Application No: LU/68/14/PL

Recommendation Report for Planning Permission

LOCATION: Vacant land North of
45A West Way
Littlehampton

PROPOSAL: Erect new building comprising 4 No one-bedroom flats

Dwg No. 45WW-Hob-Flats-01

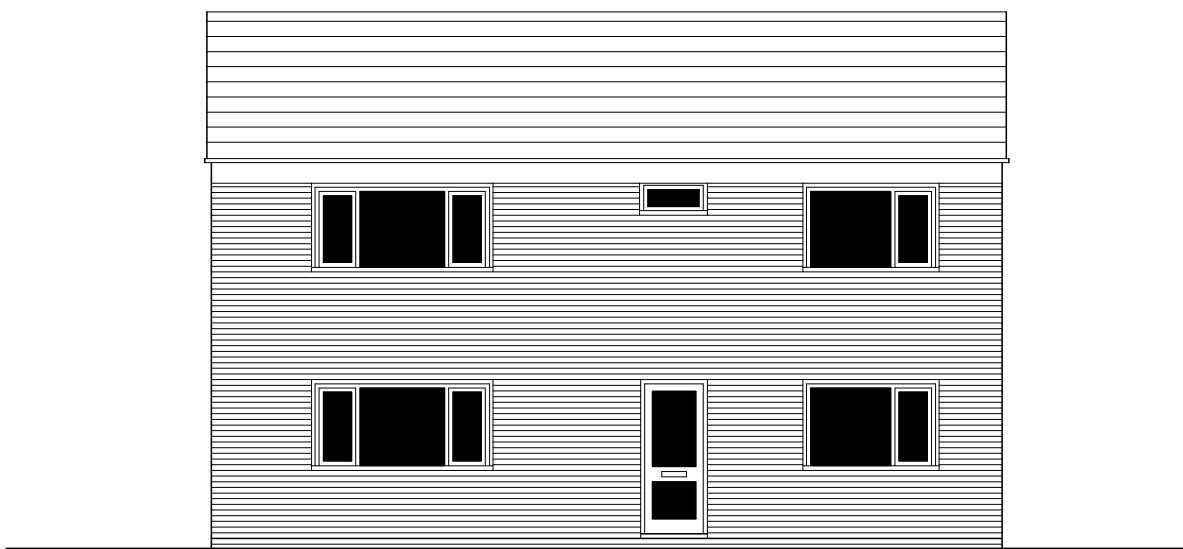
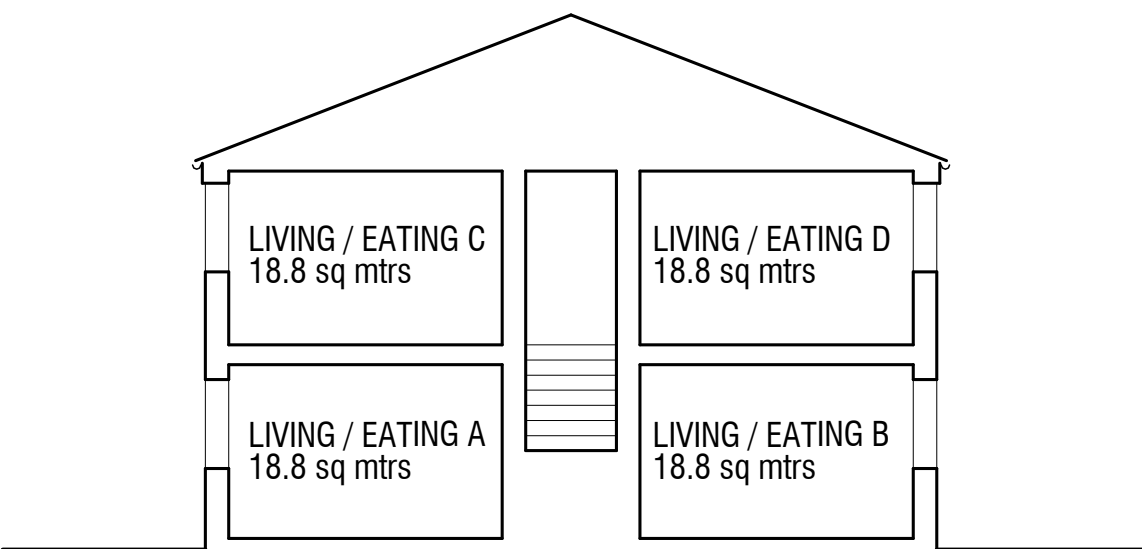
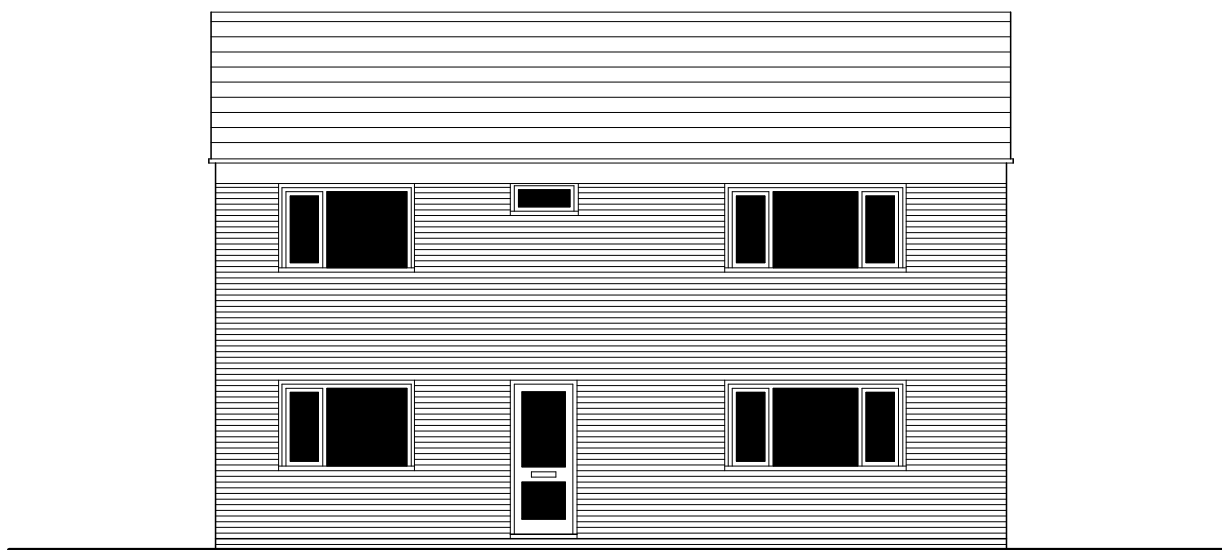
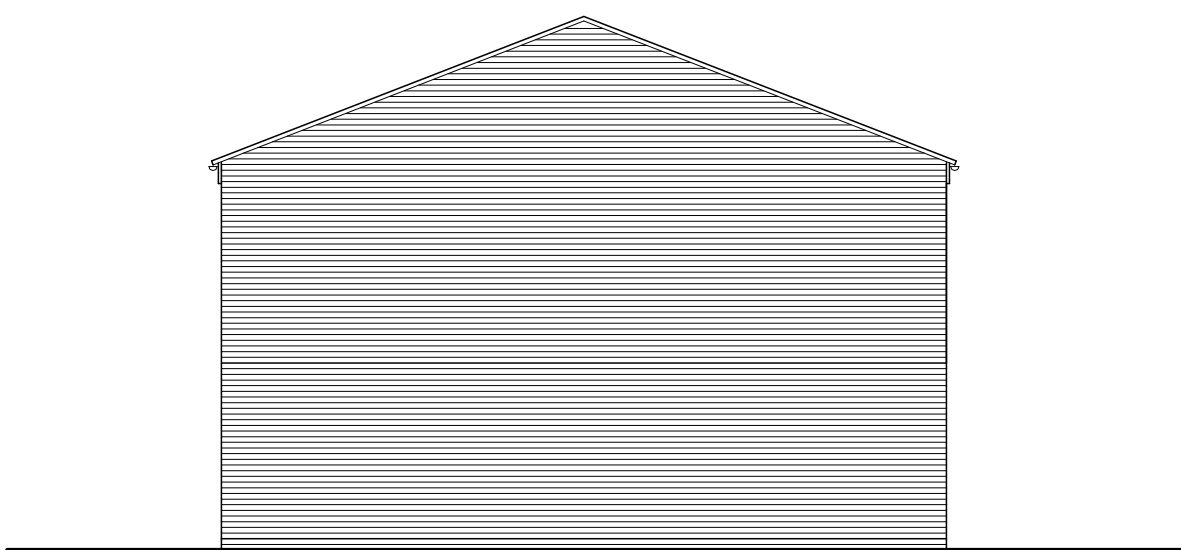
Objection. This is already a very densely populated area in a deprived Ward and as such it is considered that the proposals constitute an overdevelopment of the site. The quality of the design is poor and unimaginative and does not provide satisfactory access to the car park from the front of the properties.

The design is very similar to the adjacent terraced dwellings in terms of its roof profile and proportions. The car parking is easily accessible.

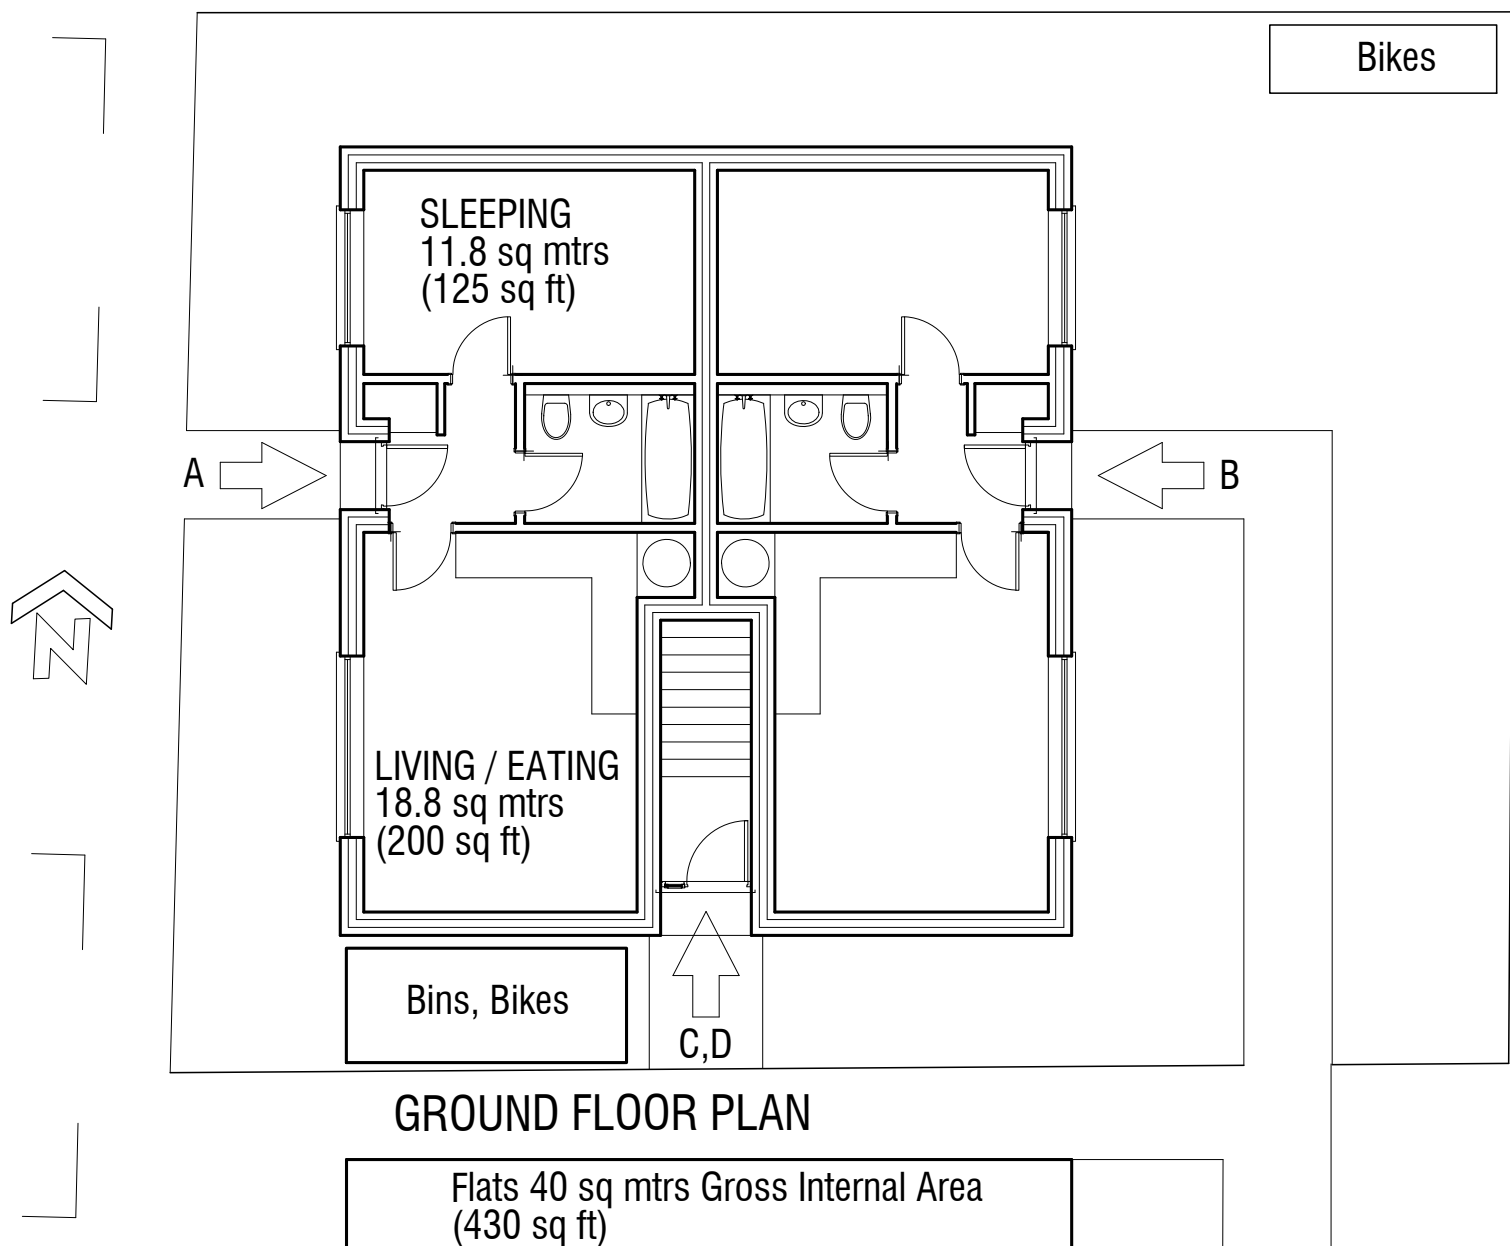
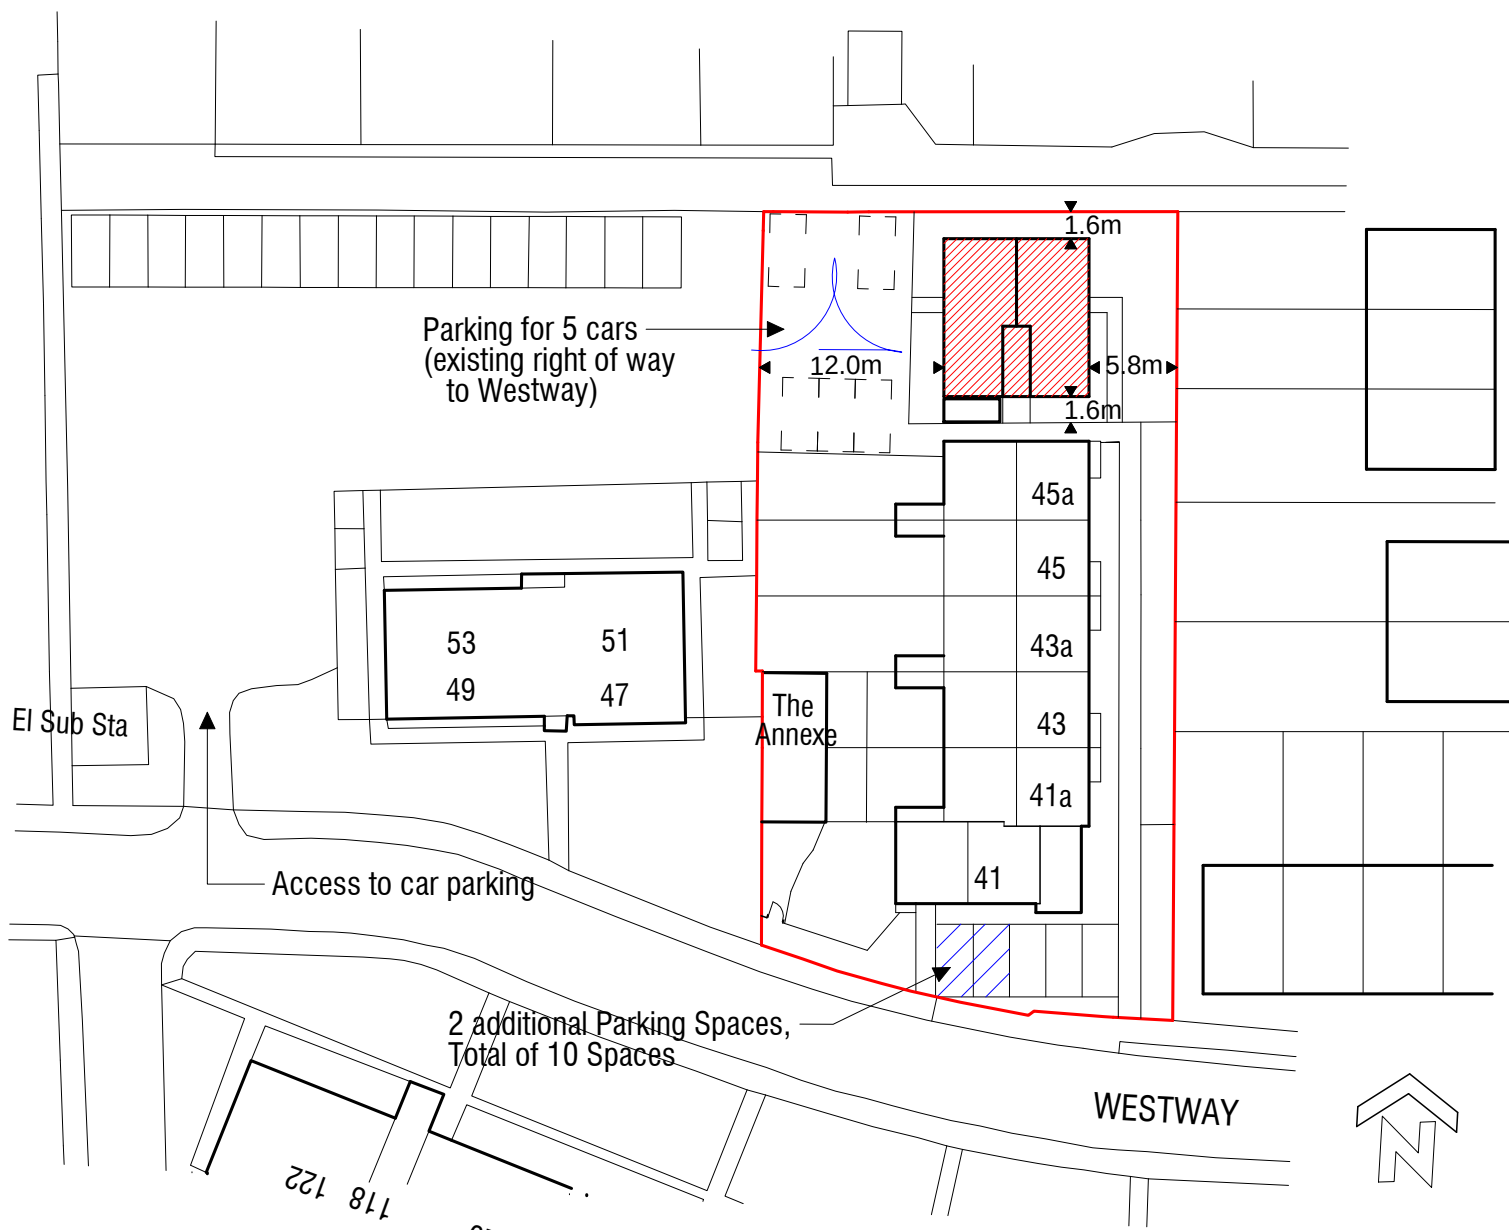
The proposed units would be located behind other dwellings in the locality. The distance to the side boundary with property rear gardens in Grand Avenue is 5.5m and this is acceptable to ensure no adverse overbearing effects result. No first floor windows are proposed in this elevation so there would be no loss of privacy resulting.

The dwellings are located 5.8m from the eastern boundary with the rear boundaries of adjoining properties. This would generally be acceptable especially given that it is directly comparable with the distances of 41a and 45a from the eastern boundary and the dwellings to the rear and is therefore considered acceptable in terms of overbearing impact. The rear elevation to rear elevation distance between the dwellings would be 18m. This is adequate to ensure no materially adverse overlooking would result. The properties would be in line with nos. 41a to 45a and there are no windows in the north end elevation of no 45a. Therefore there would be no adverse effect on the residential amenities of this property.
